Case Officer: Linda Griffiths

Applicant: Persimmon Homes South Midlands Ltd

Proposal: Discharge of Conditions 4 (Biodiversity Enhancement Strategy) and 10 (Tree Pit Details) of 22/02068/REM

drawing / figure number
Figure 1

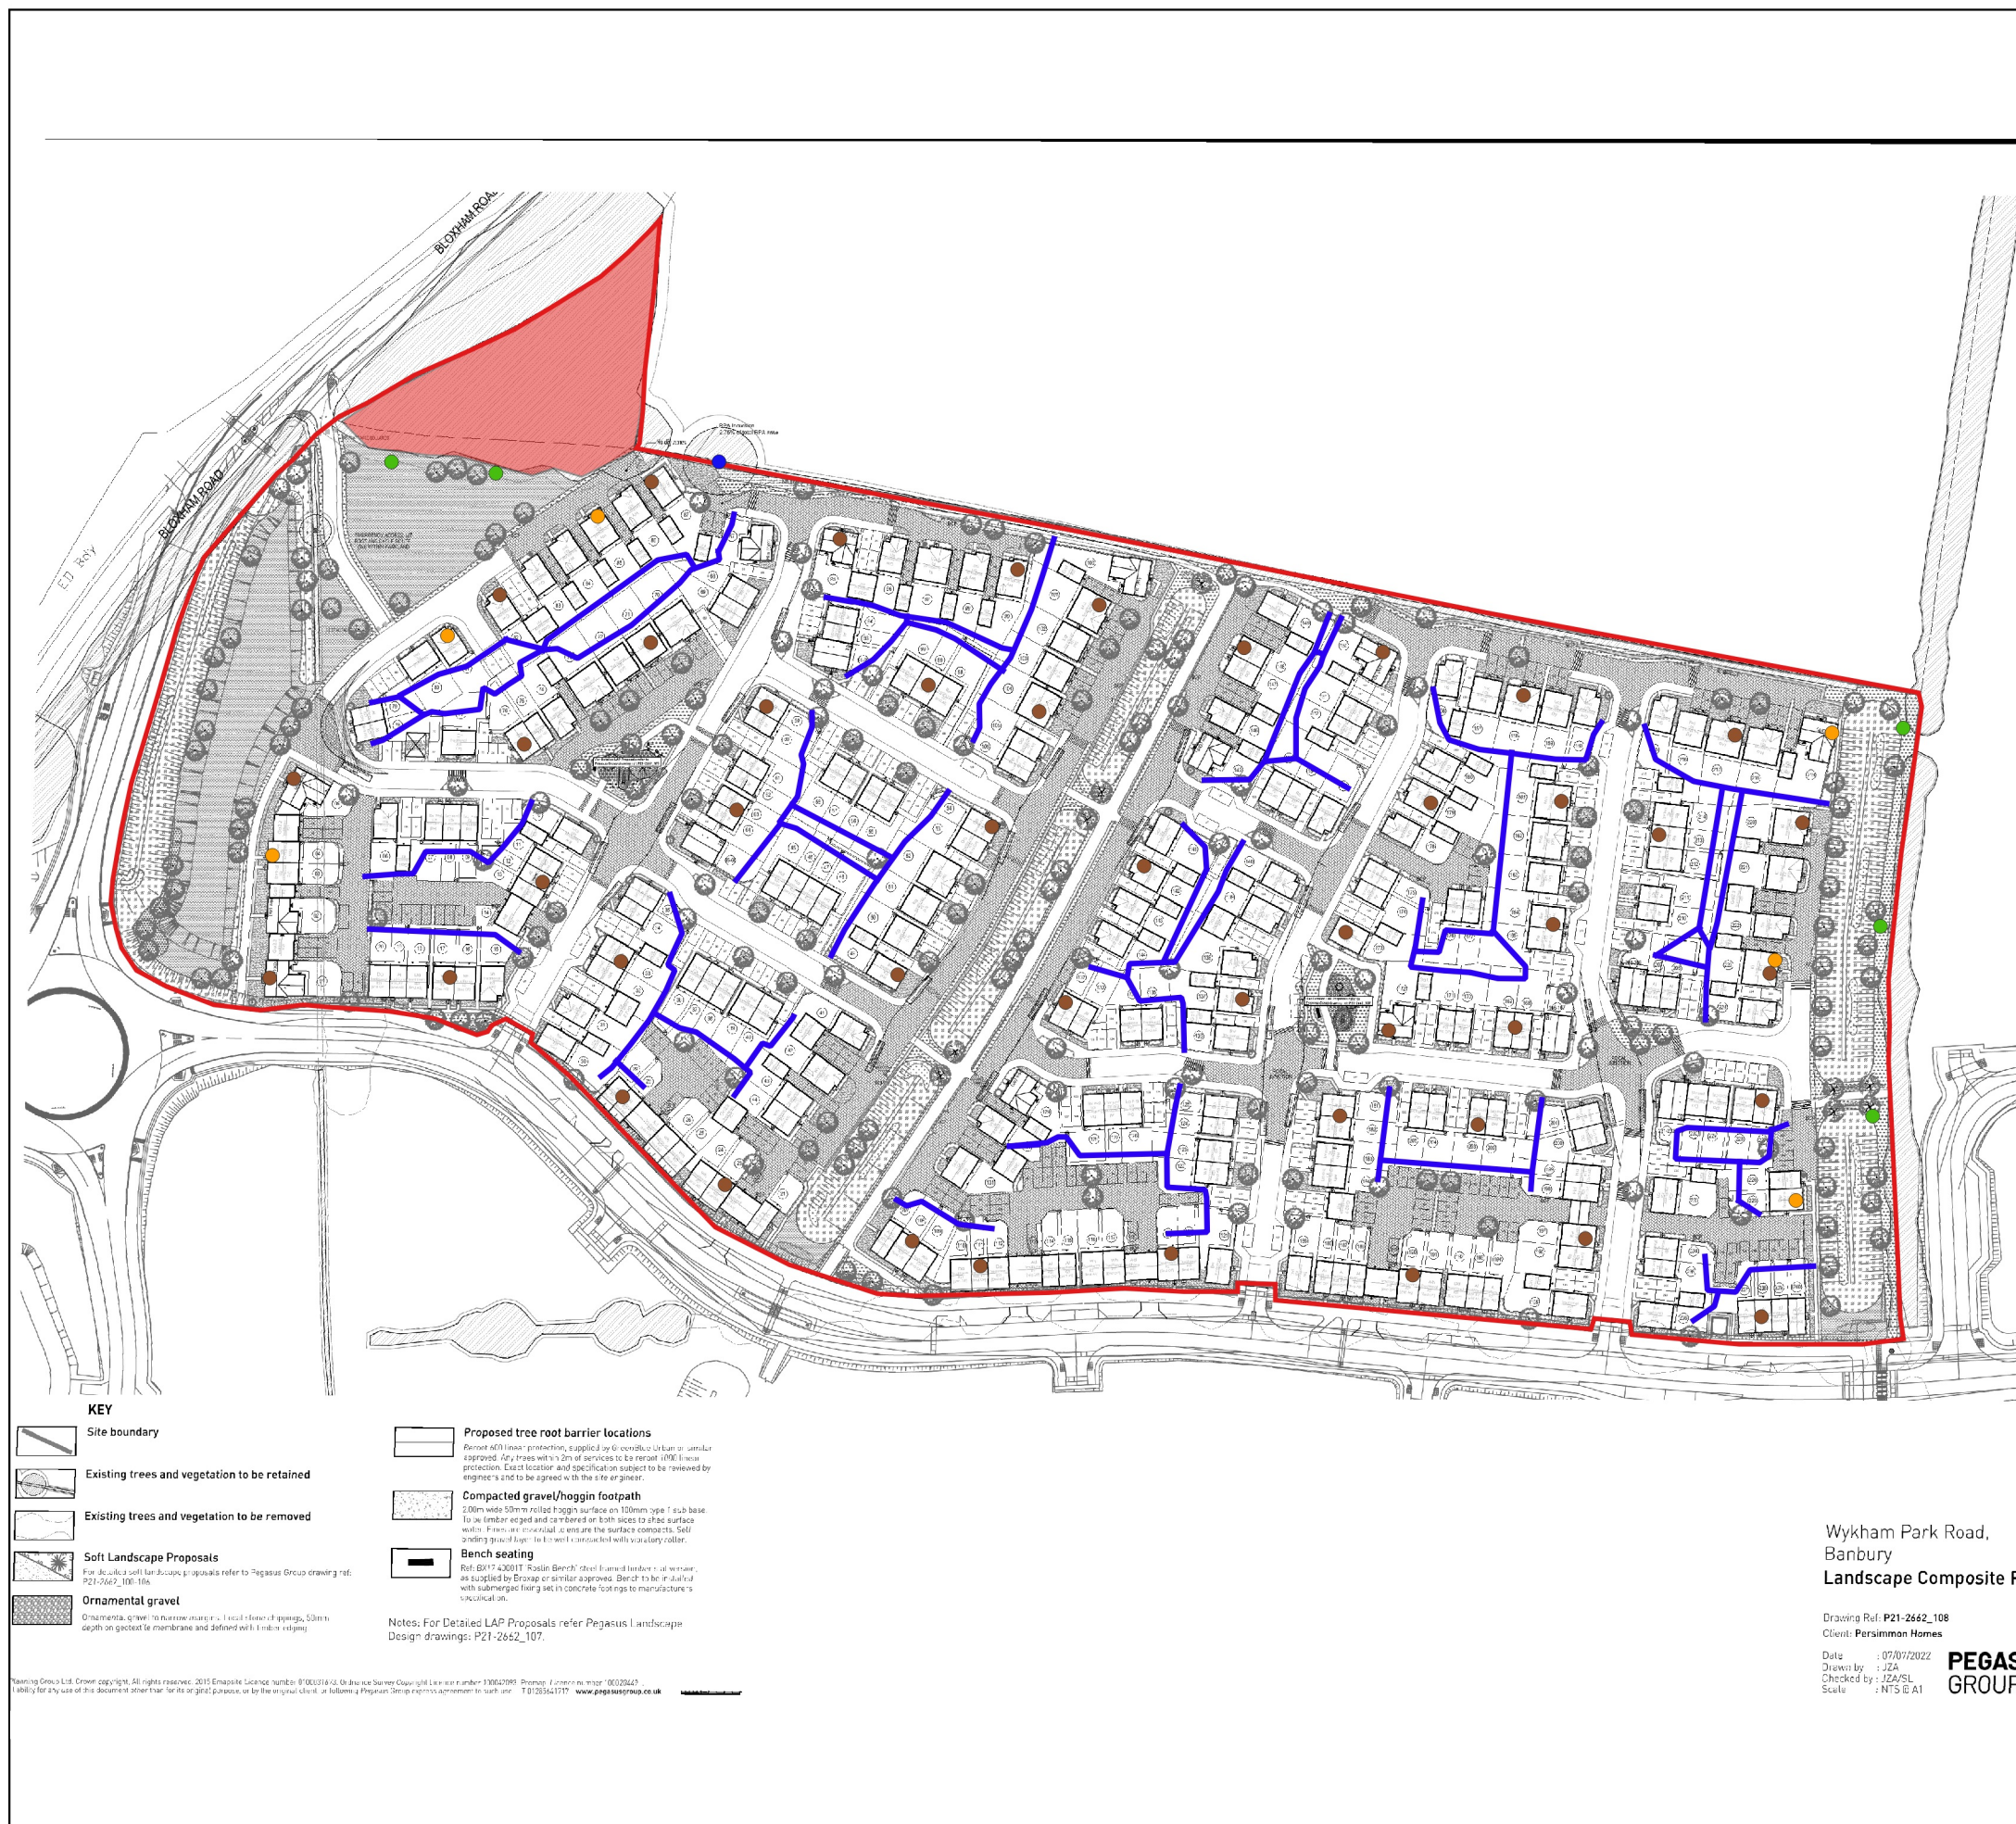
5.1. Condition 4 – requires the submission and approval of a Biodiversity Enhancement Strategy. The ecologist advised that the initial submission could not be discharged as several revisions were required. The strategy with numerous tables was deemed

confusing and inconsistent. Bat/bird/habitat boxes need to be installed during the construction phase if built in. We seek the equivalent of a minimum of one bat or bird (or potentially invertebrates) provision per dwelling albeit that these may be best clustered. The hedgehog highways proposed through fencing are welcome, however a specific sign should be placed above fence holes and information given to future residents to try to ensure their retention. There are only two log piles shown and whilst they are likely to be of benefit to biodiversity it is not proposed to maintain/renew/monitor these after year 1. It was requested that further log piles be considered and that after 5 and 10 years they should be renewed or added to where possible.

- 5.2. The comments made by the Ecology Officer were forwarded to Persimmon and a revised Biodiversity Enhancement Strategy was received in September. This revised version is now considered acceptable by the Ecologist and the condition can therefore now be discharged accordingly.
